# Planning Services Sign Permit Review Form

Date of Submittal	Application Number	Applicant	Landowner
8/28/2023	SIGN2308-0001	<b>G and J Development LLC</b>	<b>DR Horton</b>

Contact Person	Contact Number
<b>No contact person named on Application</b>	<b>919-669-1246</b>
Sign Location	PIN Number
<b>Corner of Tim Currin Rd. and Black Creek Dr.</b>	<b>0528-56-8730.000</b>

## ENTRY SIGN DIMENSIONS

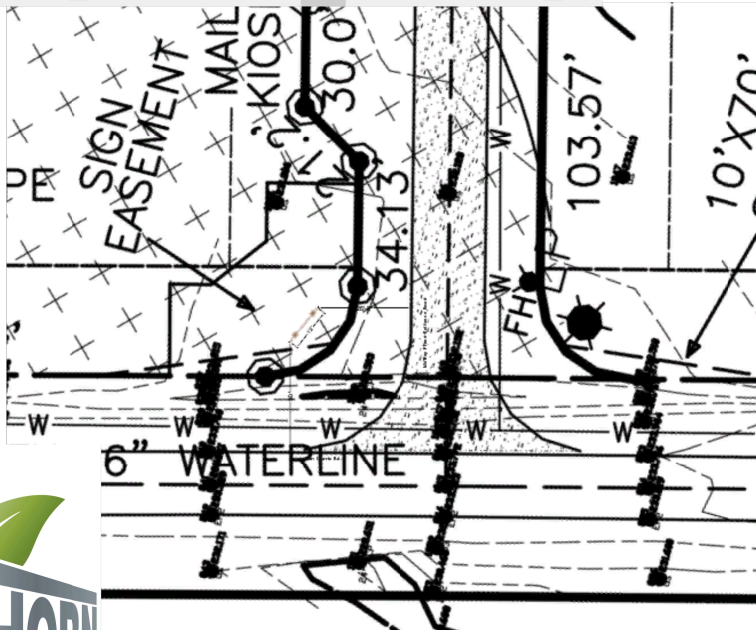
Comments	<p><b>-Please confirm that the setback information on the plat is from the edge or ROW and not the edge of pavement</b></p> <p><b>-The sign exceeds the maximum size permitted for subdivision signs. 50 square feet is permitted, however the sign measures 72 square feet.</b></p>
----------	--
